Reference No:	2023/62/93646/W
Site Address:	1-3, Banks Road, Golcar, Huddersfield, HD7 4LX
Description:	Removal of existing porch and erection of replacement porch, removal of existing garage and erection of two storey side extension
Recommending Officer:	Molly Storer

DECISION – CONDITIONAL FULL PERMISSION

Officer Report

Proposed South East Facing Front Elevation
Scale 1:100

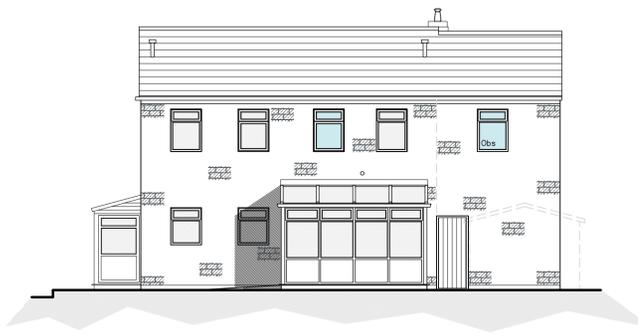
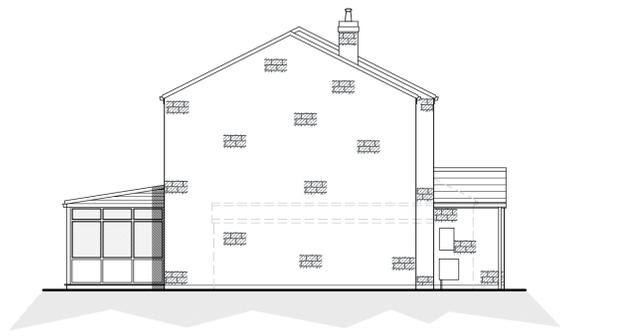
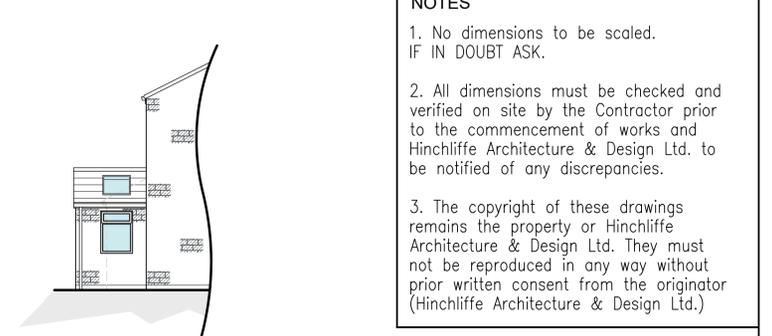
The proposed extension would be set back from the front elevation of the dwelling by 0.5 metres and would project to the side by 3.5 metres. The extension would be 7.1 meters in length. It is proposed that the eaves height would be match the existing with the ridge line being set down from the existing by 0.25 metres. This extension would replace an existing single storey, prefabricated, detached garage. Construction materials would be to match the existing.

Whilst the proposed side extension does not strictly comply with the requirements of the SPD, due to it being subservient to the original dwelling and replacing an unsympathetic addition it is therefore considered that the proposed works, in this isolated case, are considered acceptable within the remit of Key Design Principles 1 and 2 of the SPD.

The proposed porch would be identified as a front extension in terms of the SPD. The proposed porch would be set well back from the pavement, is small and subservient to the host property, the materials would match the existing and it is considered that the porch would not unreasonably affect neighbouring properties. Therefore, compliant with the SPD.

The proposed construction materials for the two elements of the proposals would be artificial stone and brick low level banding course for the walls and concrete tiles for the roof with brown uPVC for the openings to match the existing property. As such, these would comply with Key Design Principles 1, 2 and 9 of the SPD.

There are no proposed openings within the southwest side elevation facing the rear of properties on Banks Avenue. Therefore, this mitigates any harm from overlooking at close quarters from this elevation.

Proposed Site Layout
Scale 1:200

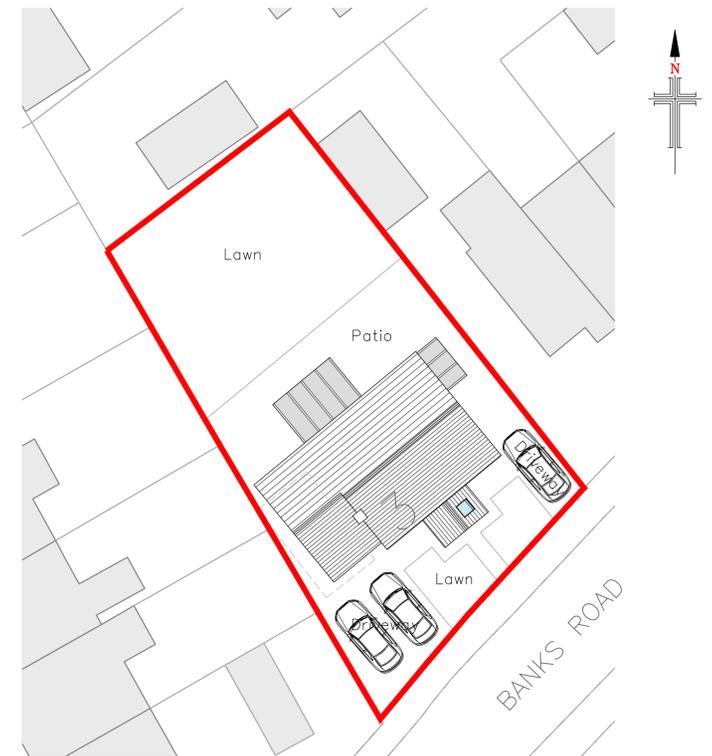
In this case the garage provision for the property would be lost as the submitted block plan indicates the removal of the garage however as the garage is prefabricated, it is unlikely to meet modern space standards to occupy a vehicle.

The extensions associated works would result in a 4 bedroom property. As such, the SPD requires 3 no. off-street parking spaces to be provided. In this case, three parking spaces could be created on the existing driveway which is shown on the plans. A condition requiring the vehicular parking area(s) shown on drawing 218-23-PL02RevB is recommended to be included on any grant of permission, given the creation of such parking areas would ensure adequate off street parking provision to serve the additional / existing accommodation and that an area of soft landscaped amenity space would remain to the front of the host property and as such the provision of such parking area(s) would not have a detrimental visual impact.

4. Prior to the development being brought into use, the vehicle parking areas shown on drawing 218-23-PL02RevB shall be provided. All further hardstanding which is required to be provided shall be surfaced and drained in accordance with the Communities and Local Government; and Environment Agencies 'Guidance on the permeable surfacing of front gardens (parking areas)' published 13th May 2009 (ISBN 9781409804864) as amended or superseded; and thereafter retained throughout the lifetime of the development.
